WEST SUSSEX COUNTY COUNCIL CONSULTATION

TO:	Arun District Council FAO: Anita Gardner
FROM:	Highways, WSCC
DATE:	14 Jan 2019
LOCATION:	Garage Premises, Littlehampton Road, Ferring, Worthing, BN12 6PB
SUBJECT:	FG/171/18/DOC Approval of details reserved by condition imposed under FG/39/18/PL relating to conditions 3-surface water drainage, 4-ground contamination risk, 9-position & intensity of lighting filments, 14-lighting scheme, 15-Construction Management Plan & 16-ground contamination risk. Additional information received.
DATE OF SITE VISIT:	
RECOMMENDATION:	☐ Advice ☐ Objection ☐ Modification ☐ No Objection ☒ More Information ☐ Refusal
S106 CONTRIBUTION TOTAL:	£ See below for breakdown.

APPENDIX C – DELIVERY VEHICLE (LARGEST ANTICIPATED) TURNING HEAD PLAN

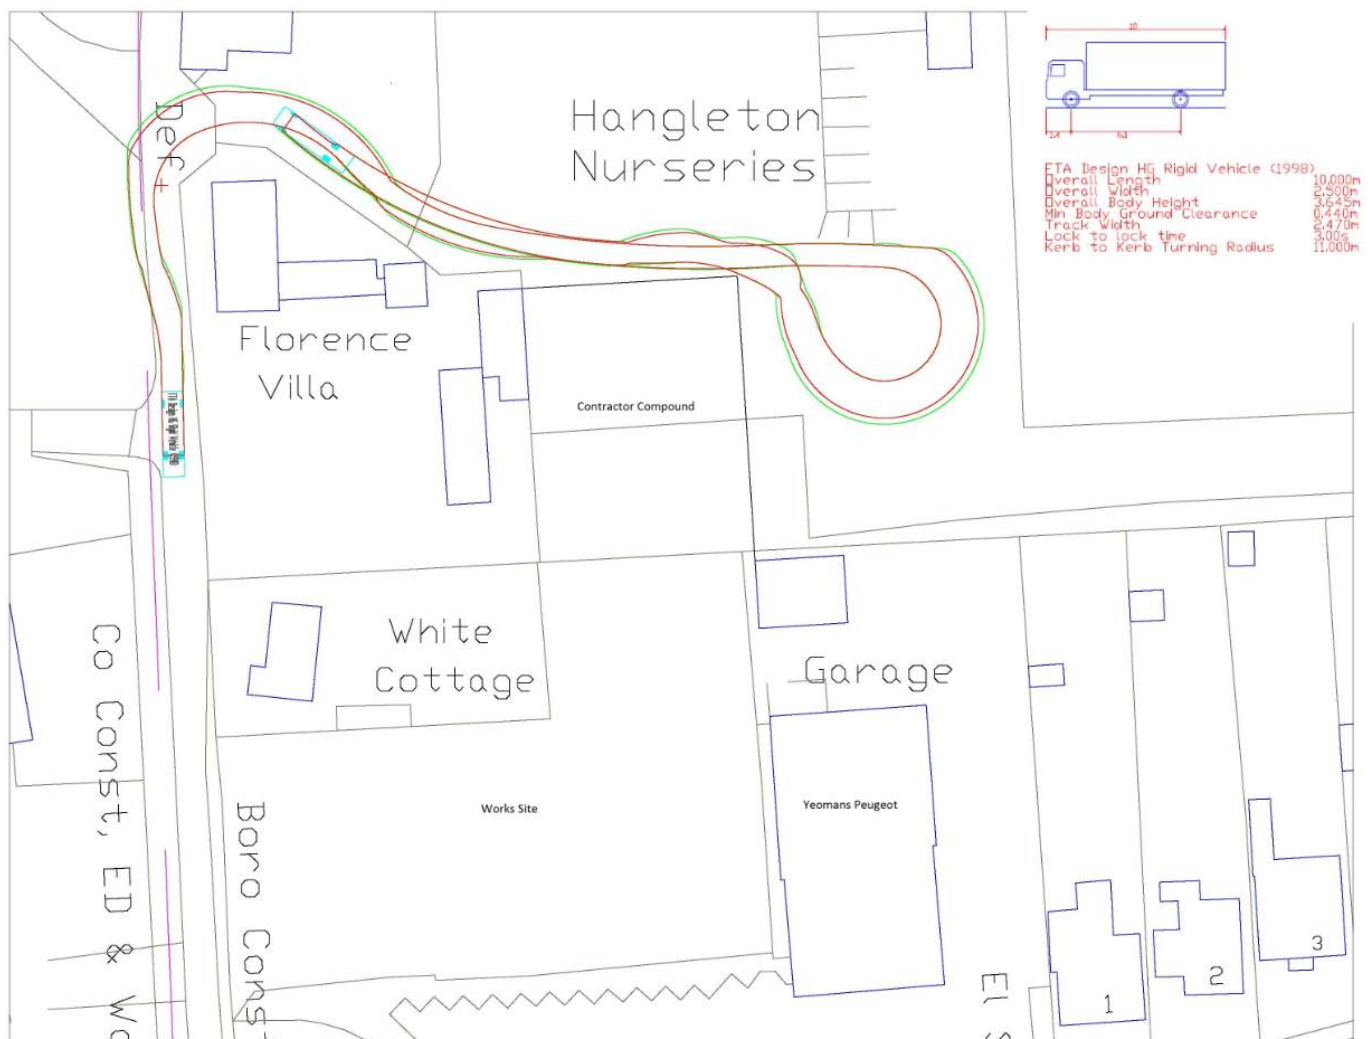
An updated Costruction Management Plan has been submitted which includes drawings with basic swept path overlays. The swept paths shown are for the worst case scenario of a crane and a rigid 10m truck. The drawings show there will be a considerable amount of overrun on the west side verge which is narrow, includes a drainage ditch and is bounded by mature vegetaion. The verge appears to by public highway but the vegetation is likley to be private.

Can the applicant provide a detailed and coloured swept path analysis showing wheel and over-hang tracking curves.

It is highly likely that a considerable level of damage will occur to the verge and ditch (which may have a secondary impact on drainage) which will need to be remedied during construction. A S59 licence is therefore required please see informative below.

APPENDIX D – CRANAGE

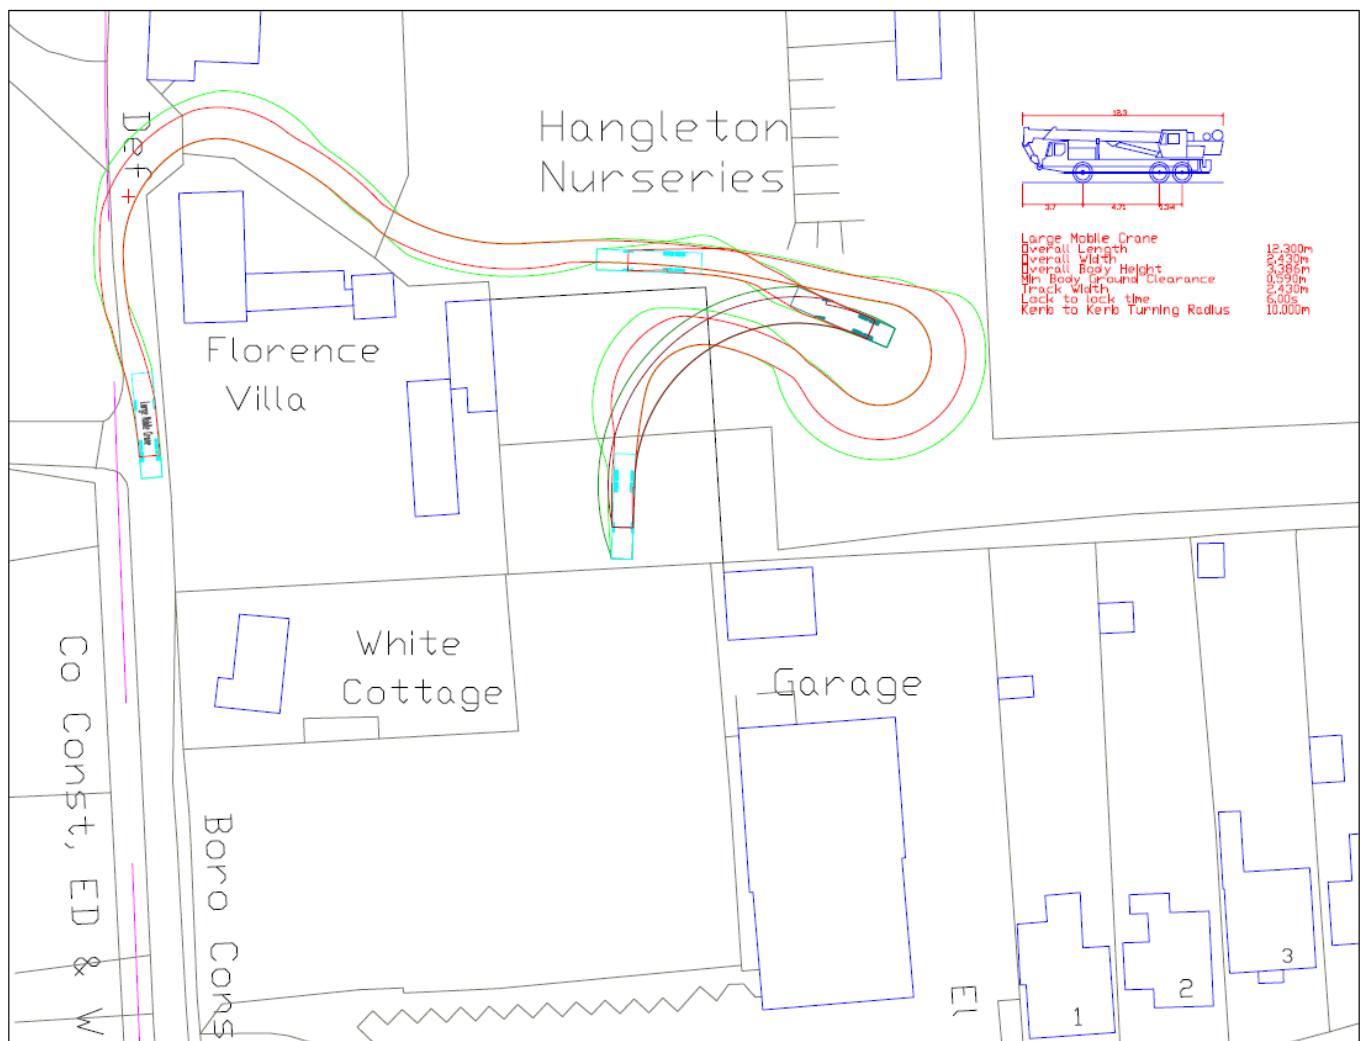
The crane will have significant problems in attempting to enter the site and may also cause damage to the vegetation to the west of Hangleton Lane. It is recommended the applicant consults with private landowners prior to commencement of construction.
